**Re: Final Plat for Proposed Minor Subdivision Plat Lot 12, Block 10, Eastern Addition**

The sketch plat review held March 19, 2025 under PS-2025-00047 are addressed below:

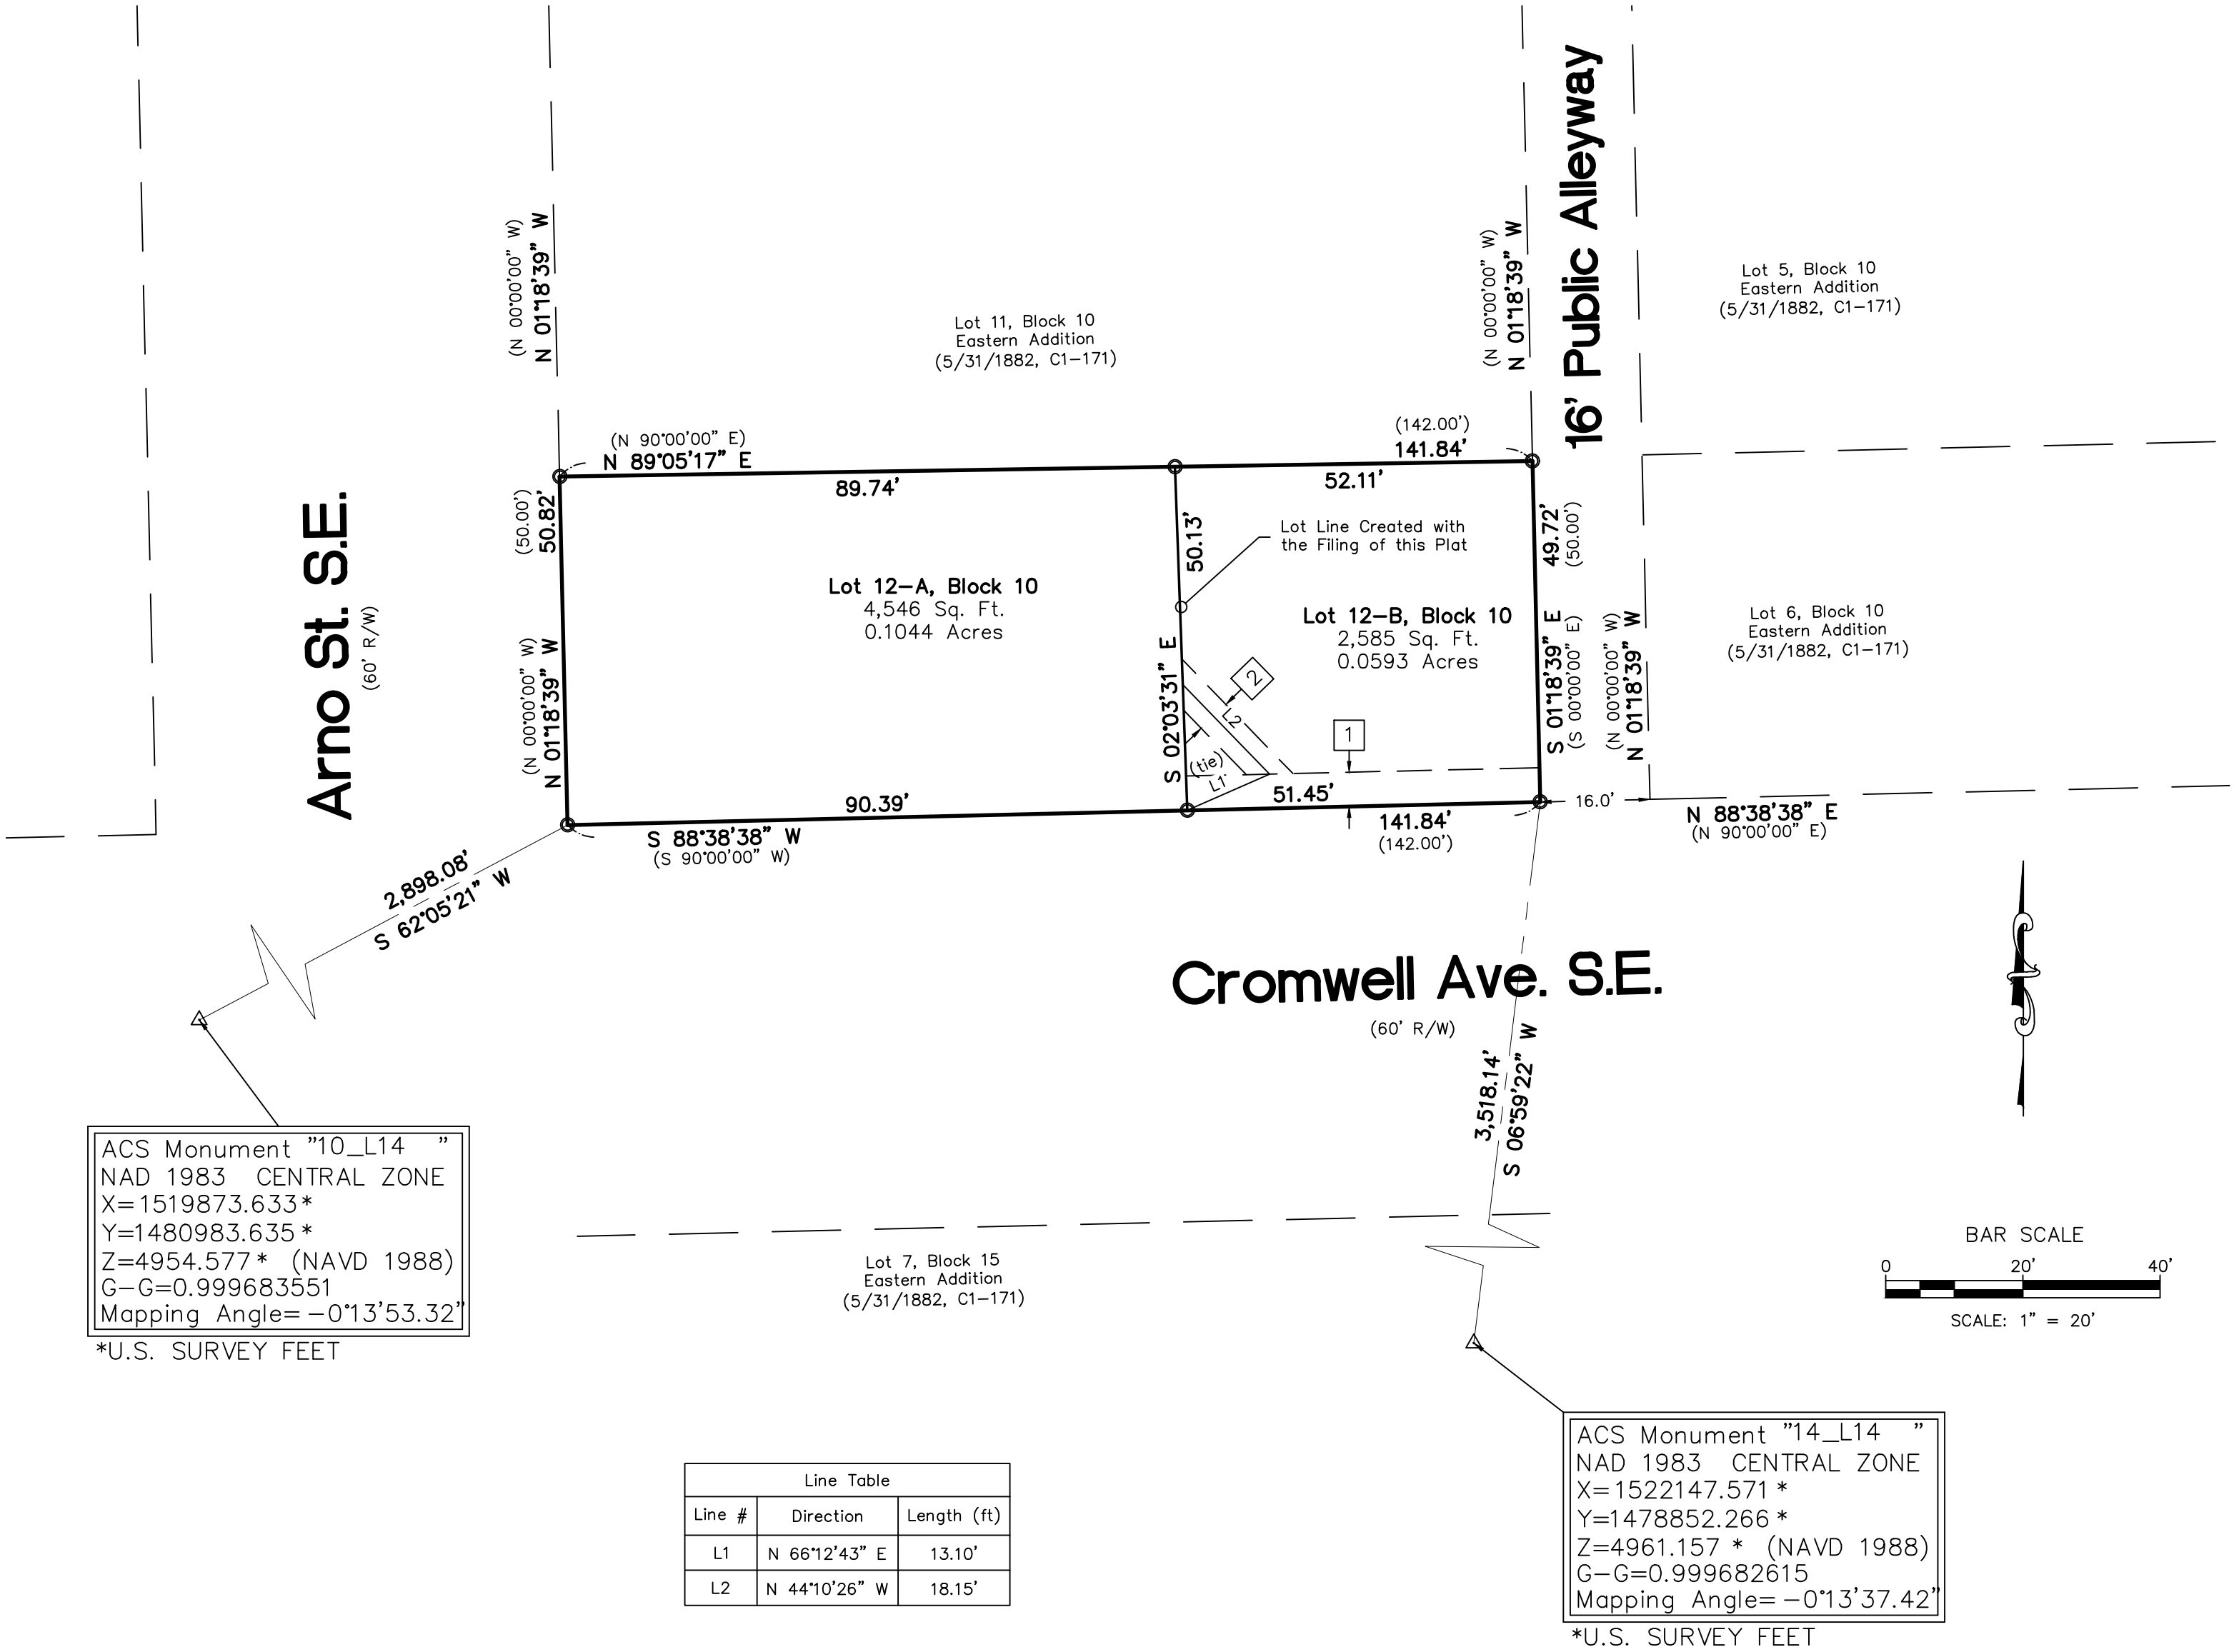
1. The 922 Arno St SE residence appears to have an existing ABCWUA water and sewer account, possibly two accounts, but neither are near the 507 Cromwell Ave SE residence. It may be that the residence at 507 Cromwell Ave SE is sharing the account(s). If this is the case, separate services and accounts will need to be established for the subdivided lots with existing dwellings prior to plat approval.

2. If proposed lot 12-A cannot acquire an easement to get to the public sanitary sewer line along the Alley, the site may need to construct a public sanitary sewer line along Cromwell St. up to the property line such that it can get a perpendicular connection to the new sanitary sewer line.

4. Include all public water and/or sanitary sewer easements on the plat, including those that are adjacent to the subject property's boundaries. Surveyor shall field verify the location of existing public water and/or sanitary sewer infrastructure to determine if existing public water and/or sanitary sewer easements are sufficient. If the easement(s) does not exist, a new easement shall be granted. The width of the easement shall be the standard width, unless specified by the Water Authority.

6. The surveyor shall field verify the location of existing private water and/or private sanitary sewer services to determine if private service easements are needed to preserve the existing service(s) for the newly created lots. The width of the private service easement shall be determined by the engineer or surveyor.

7. Proper private water and/or private sanitary sewer service easements shall be granted for access to public waterline and/or public sanitary sewer for proposed lots which do not have direct

1. Sidewalks and buffers are adequate. The alley is shown at 16' wide, where all alleys are required to be 20' wide. ROW dedication is required. If you are unable to dedicate the ROW for the alley, you may request a determination to allow it to remain as is

Noted, water and sewer lines are separate as shown in attached site sketch. There is a private service easement for sanitary sewer [2], granted with this plat. Waterlines fall within right-of-way and are provided by separate water meters in the residences respective frontages.

Noted, we provide justification for a determination to allow alleyway to remain as-is with the application materials.
